ORIEL WIND FARM PROJECT

Environmental Impact Assessment Report - Addendum Chapter 13 Addendum: Shipping and Navigation

MDR1520C
EIAR – Chapter 13 Addendum
A1 C01
December 2025

Table 13A-1: Further Information requested on Shipping and Navigation and details on Applicant's response.

Figure 2-2: Proposed layout of the Project and infrastructure naming

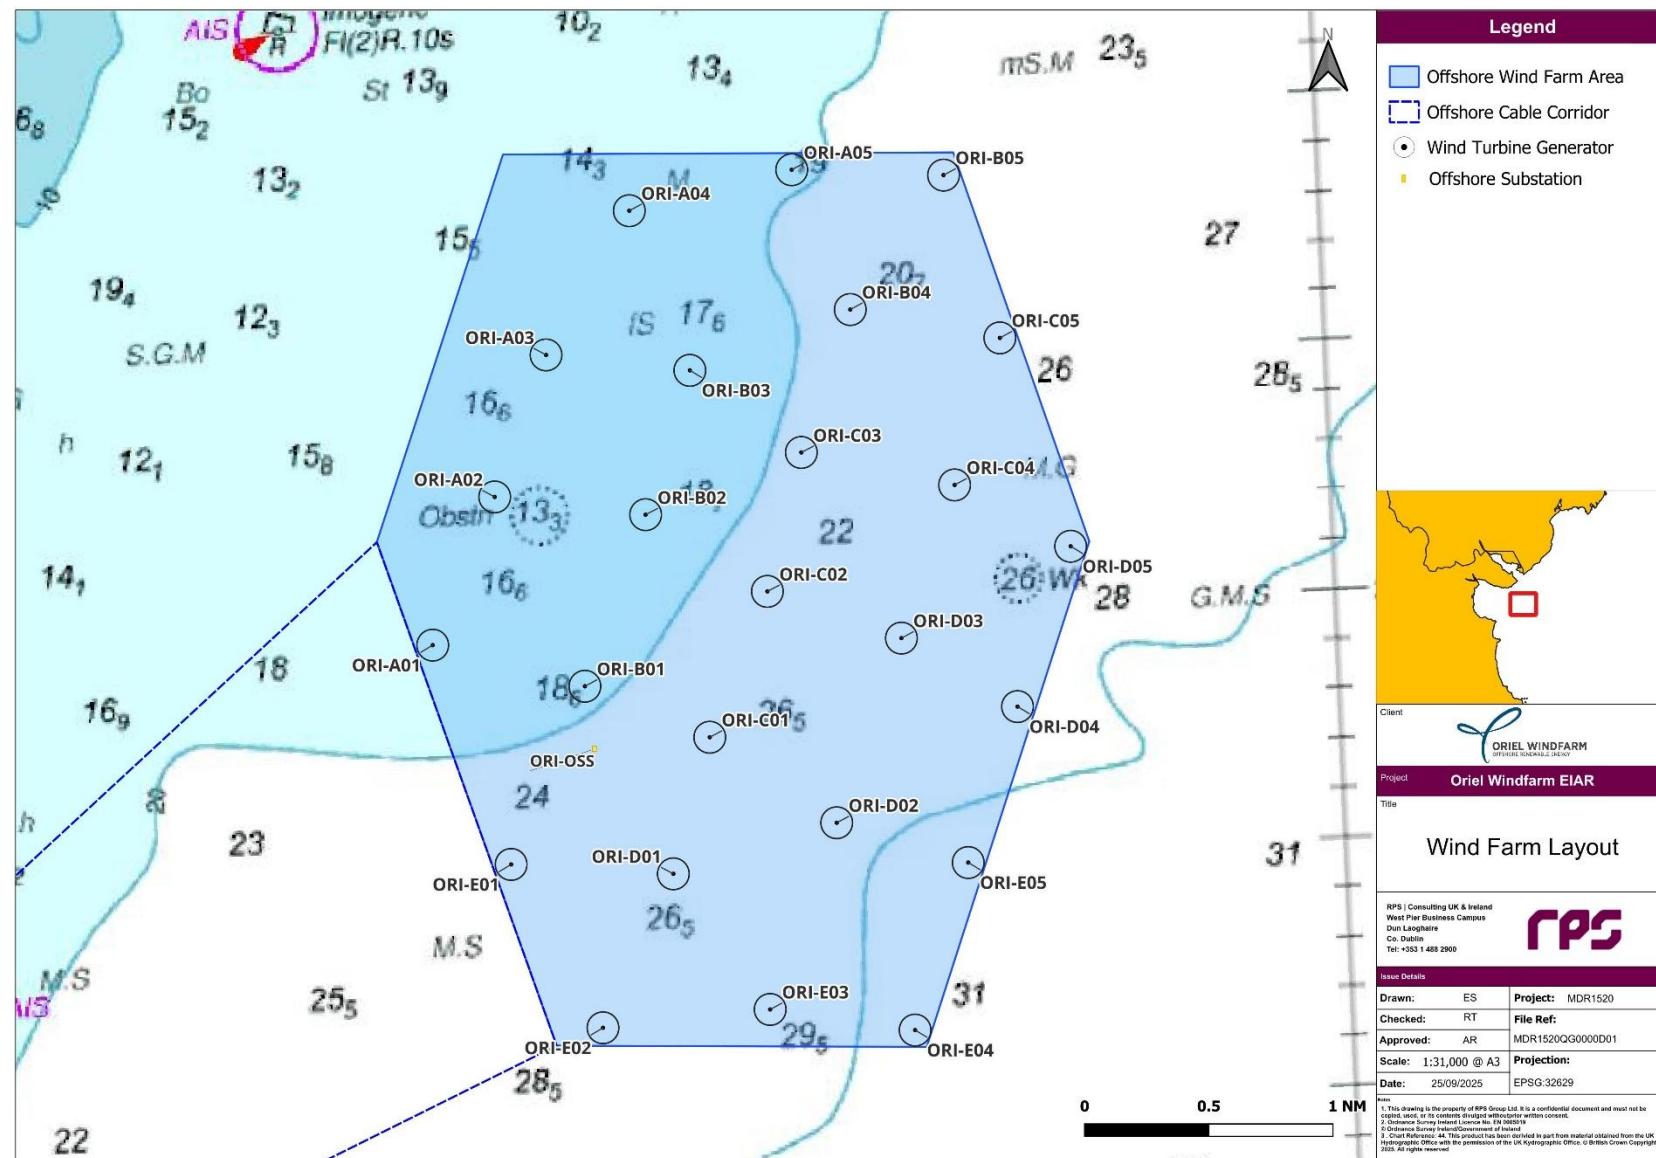
Reference	Request for Further Information	Response / Reference where further information is presented	Concluding statement
2.	The Irish Coast Guard (IRCG), through the Department of Transport, has raised concerns in relation to the layout of the proposed development with respect to search-and-rescue (SAR) access. The applicant is requested to consult with the IRCG, in addressing these concerns, and provide further information and clarification on such matters.	<p>The Applicant has prepared a response to the Department's submission, including the observations made by the IRCG. This is included in appendix 13-2: Safety Justification for Single Line of Orientation.</p> <p>The Applicant met with the IRCG in June and September 2025 to discuss items outlined in the IRCG's submission and the RFI received from ACP.</p> <p>In response to the consultation, a safety justification was prepared and is provided in appendix 13-2: Safety Justification for Single Line of Orientation.</p> <p>The IRCG responded to the Applicant's consultation confirming that the further mitigations have met their requirements.</p> <p>A summary of the key points from this consultation is presented in section 13.5 of this Addendum.</p>	<p>The evidence presented within the Safety Justification (appendix 13-2: Safety Justification for Single Line of Orientation) supports the statements made within the EIAR.</p> <p>Overall the further information and evidence presented supports the conclusion reached within the NRA.</p>

15.A	The Department of Transport has made a submission in terms of the potential impacts of the location of three specific turbines on established routes identified in traffic surveys of 2019 and 2022. The Marine Survey Office recommends that turbines ORI-A04, ORI-A05 and ORI-B05 are relocated elsewhere within the site to ensure that shipping navigation to the north of the windfarm can maintain adequate under keel clearance and a minimum safe distance from turbine ORI-A04, and the 10m contour line that lies to the east of Cooley Point and Castle Rocks. The applicant is requested to comment on the submission from the Department.	<p>The Applicant has prepared a response to the Department's submission, including the observations made by the MSO. This is included in appendix 13-3: Response to Department of Transport (MSO).</p> <p>The Applicant met with the MSO in September 2025 to provide an update on the Project and to discuss items outlined in the MSO's submission and the RFI received from ACP. A summary of the key points discussed at this meeting is presented in section 13.5 of this Addendum.</p> <p>Following the meeting an updated mitigation proposal was issued to MSO and details of this proposal are set out in section 13.10.4.</p>	<p>The Applicant has reviewed the points made by the MSO and has provided specific comments describing why the relocation of turbines ORI-A04, ORI-A05 and ORI-B05 is unnecessary because there is sufficient depth of water and sea room for safe navigation north of the Project.</p> <p>Overall the further information and evidence presented supports the conclusion reached within the NRA.</p>
